KIRKLEES METROPOLITAN COUNCIL INVESTMENT & REGENERATION SERVICE

DELEGATED DECISION TO DETERMINE PLANNING APPLICATIONS

Reference No:	2026/62/91294/W
Site Address:	5, Clement Street, Crosland Moor, Huddersfield, HD4 5DL
Description:	Erection of single storey rear extension with raised decking and external steps (retrospective)
Recommending Officer:	Joshua Merriman

Officer Report – 2026/91294

EXISTING
SIDE ELEVATION

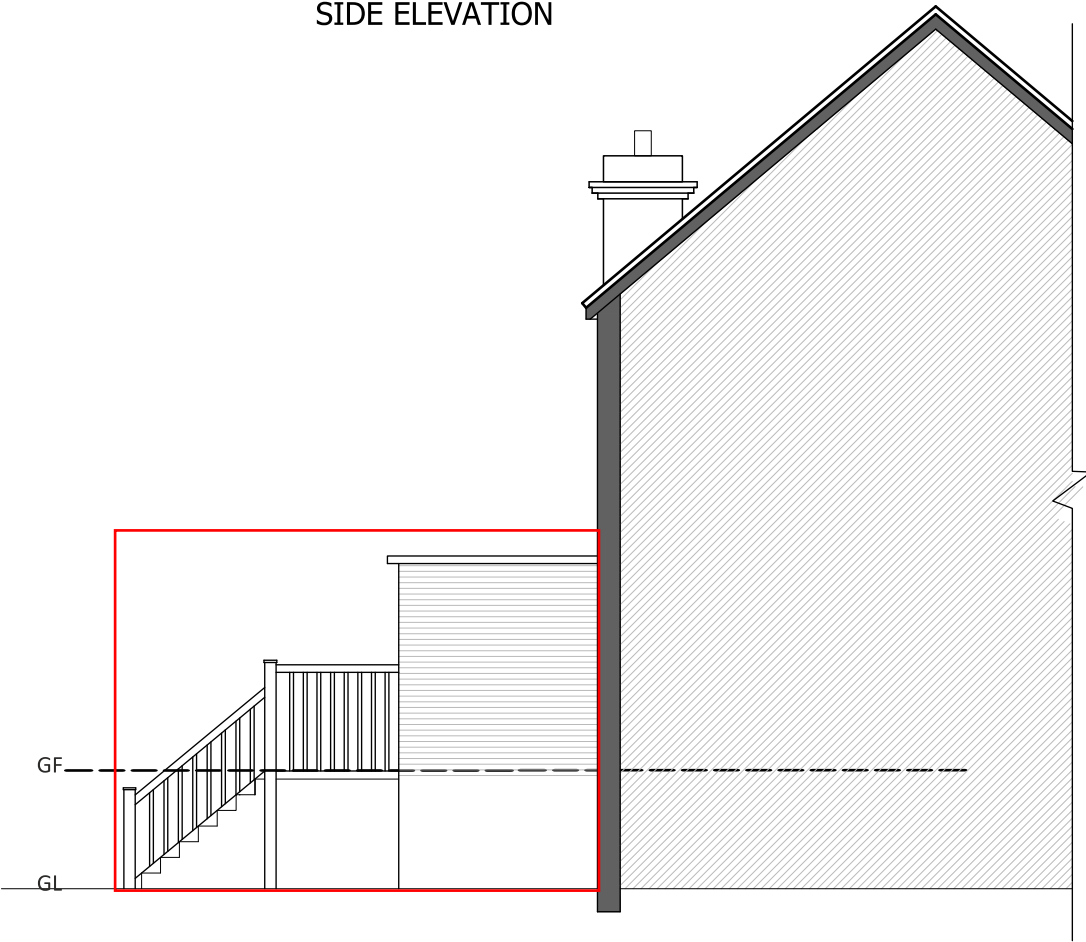
The decking area would enable direct overlooking of the rear garden areas serving Nos. 3 and 7 Clement Street, as well as the properties located to the rear of the site on George Street. Owing to its elevated position, the decking would create a platform from which users would be afforded clear views into neighbouring private amenity spaces, resulting in an unacceptable loss of privacy. Consequently, the proposal would have a detrimental impact on the living conditions and residential amenity of neighbouring occupiers.

1. The rear decking, by virtue of its siting, elevated height and proximity to neighbouring properties, would result in unacceptable overlooking of neighbouring occupiers at Nos. 3 and 7 Clement Street and the properties to the rear of the site on George Street. This would lead to a significant loss of privacy and harm to the residential amenity of those occupiers. The development is therefore contrary to Policies LP1, LP2 and LP24 of the Kirklees Local Plan, Chapters 2 and 12 of the National Planning Policy Framework, and Principles 3 and 4 of the House Extensions and Alterations SPD.

EXISTING
REAR ELEVATION

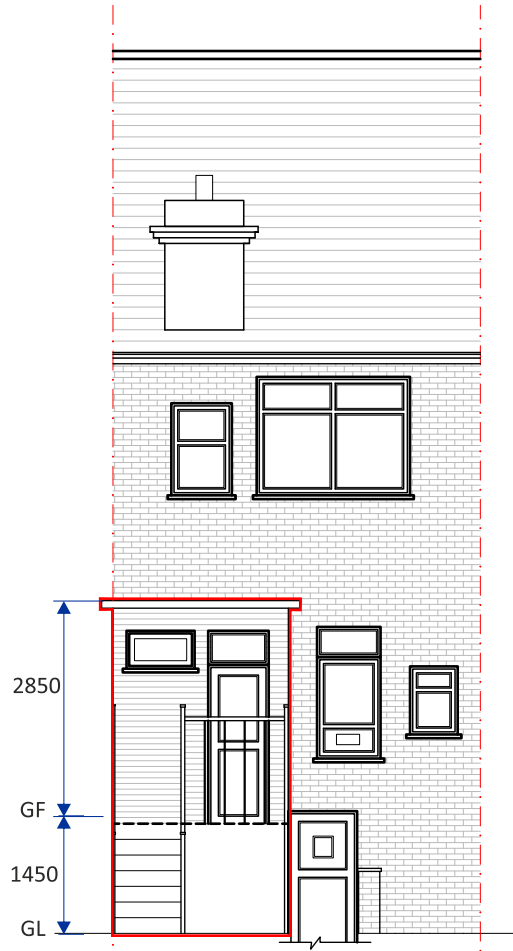
As for the rear extension, as this part of the development is much greater in scale and can be viewed from across the rear of the terraced row, it is considered that the use of such unsympathetic materials, including PVC Cladding and a flat PEDM black roof, is unacceptable and appears wholly unsympathetic in the context of the rear of the site. The neighbouring single storey rear extension which has been erected using matching and sympathetic materials, including stone and roof tiles, is considered an example of good, sympathetic design, however, the extension erected at the application property does not follow these principles and is therefore considered to appear incongruous and out of character with the street scene.

1. The single storey rear extension, by reason of the use of unsympathetic materials which fail to respect the character and appearance of the host dwelling and surrounding street scene, would result in a visually incongruous and discordant addition contrary to Policies LP1, LP2, and LP24 of the Kirklees Local Plan, Chapters 2 and 12 of the National Planning Policy Framework, and Principles 1 and 2 of the Councils House Extensions and Alterations SPD.
